Include comments made by engineering on the site plan with contours

VALENS CAPITAL, LLC
 SITE DEVELOPMENT PLAN
 3980 Walker Road
 Colorado Springs, CO 80908

PROJECT NO. _____ SHEET
 DATE: 4/3/24 **C1**

SITE PLAN KEYMAP

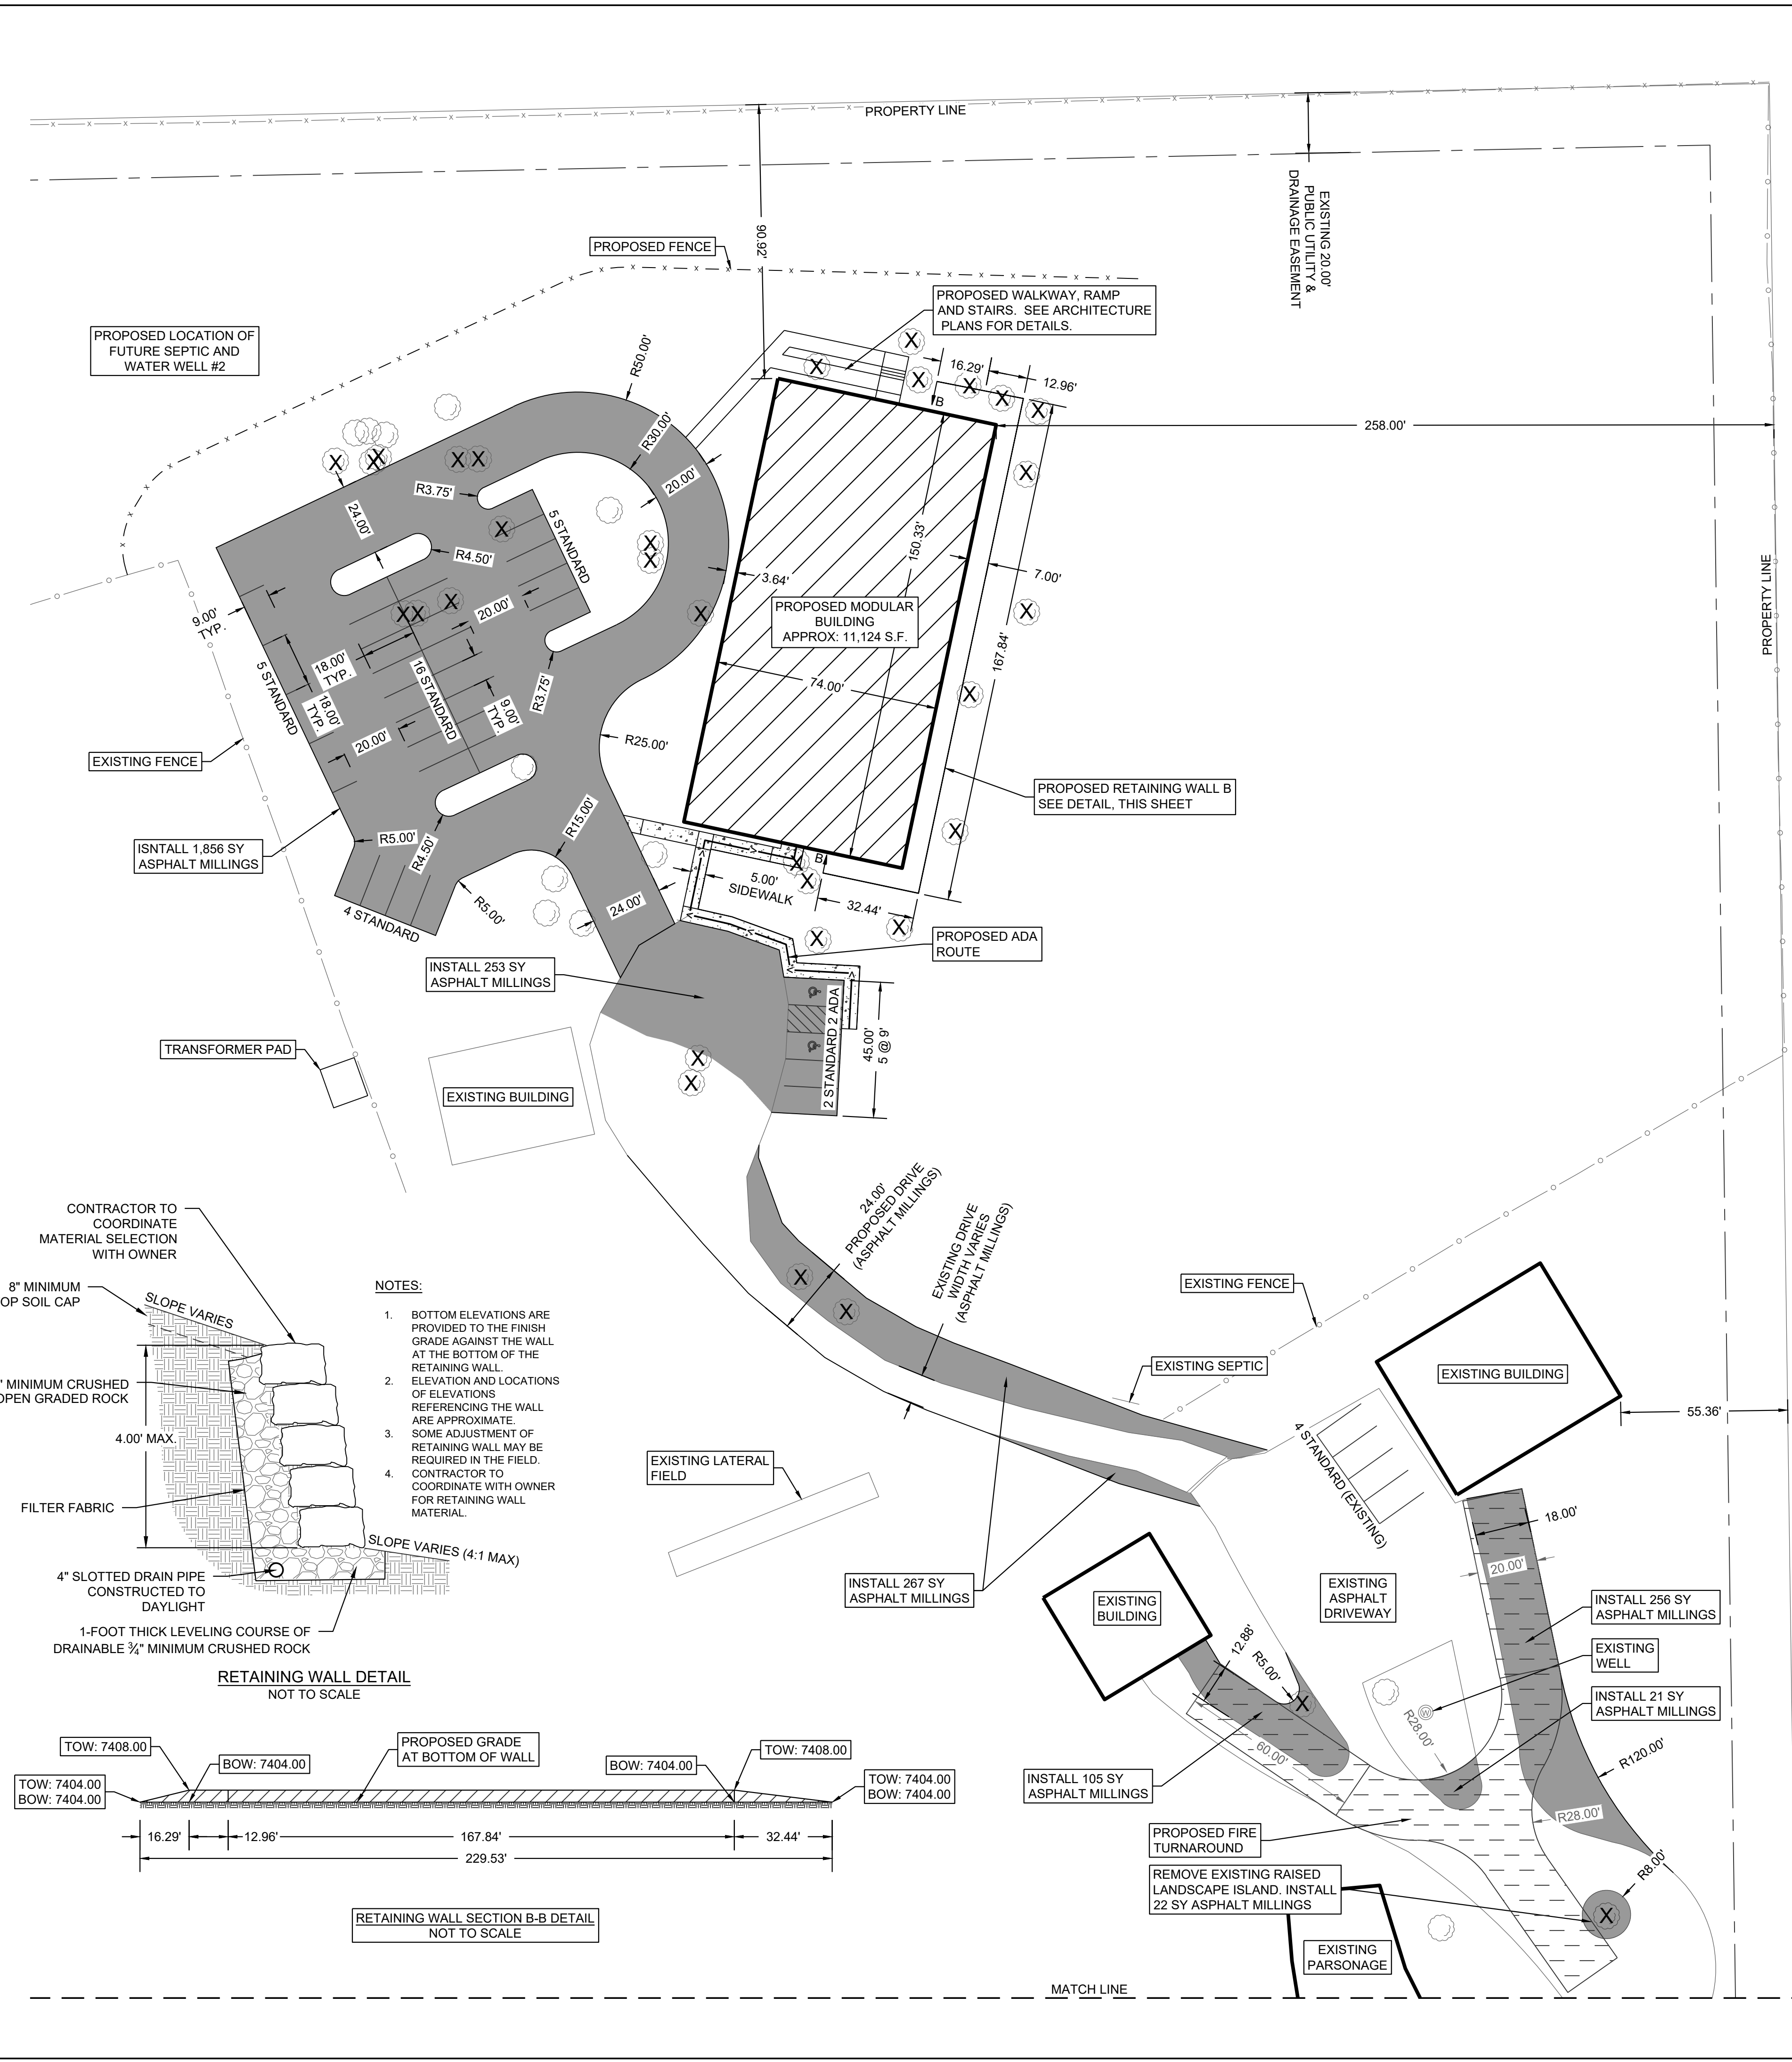
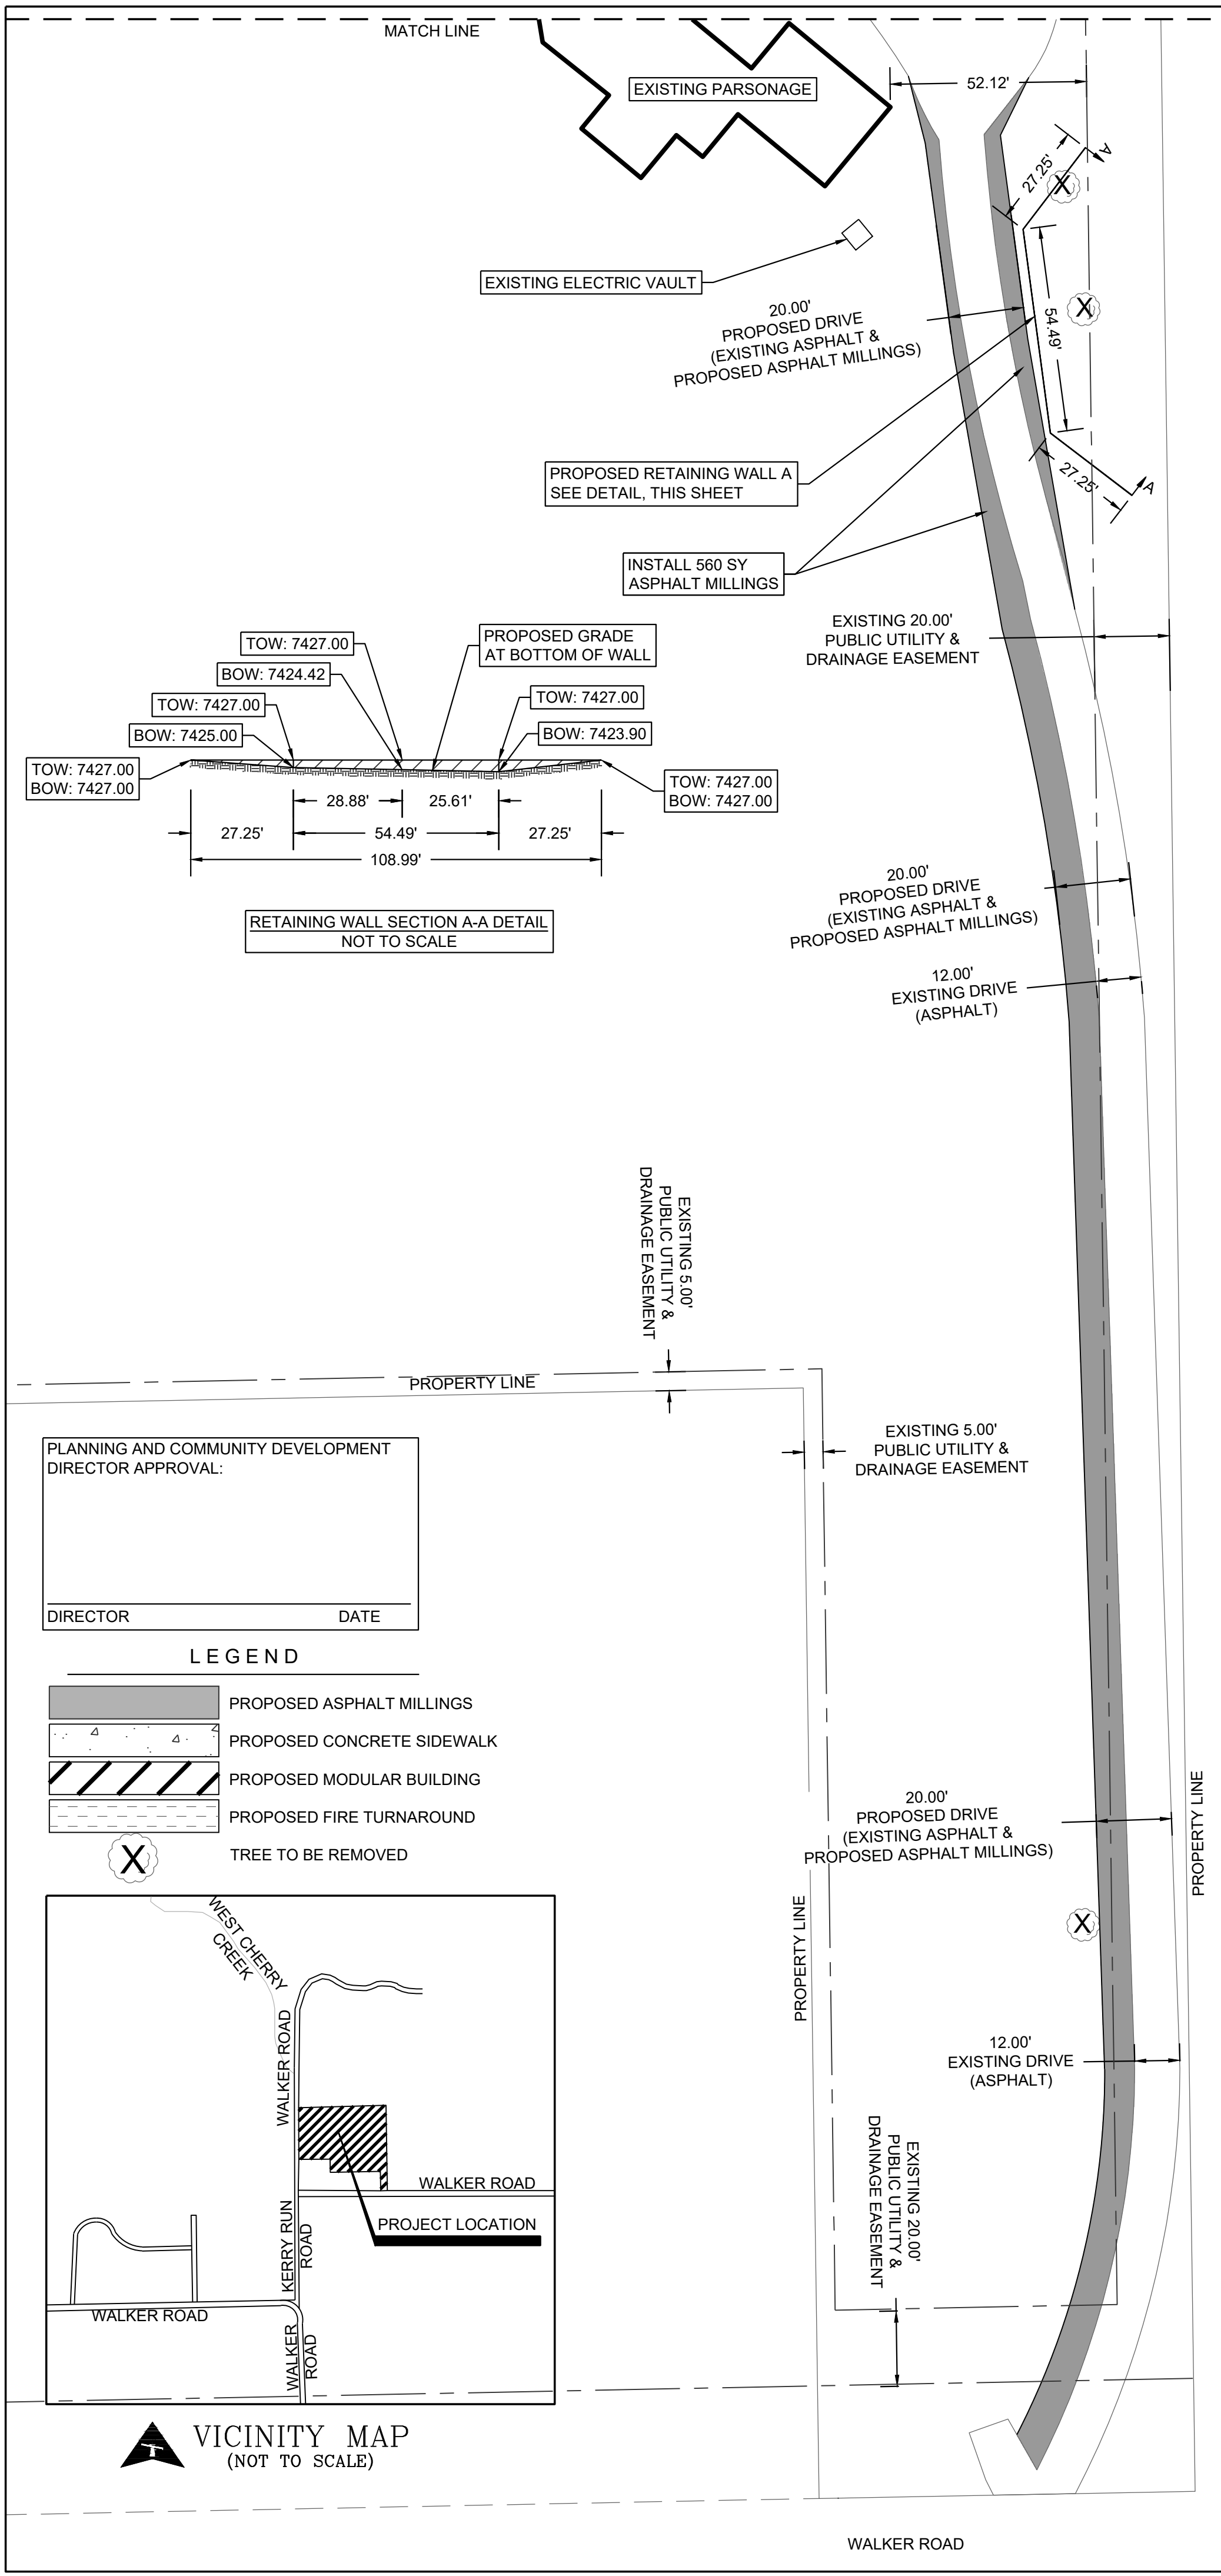
- Include lot coverage calculation.
- State the proposed land use
- Total gross building square footage
- Show location of existing well and septic locations
- Label the parsonage as talked about in your letter of intent

Please state the use of the building

Add 38 parking spaces provided
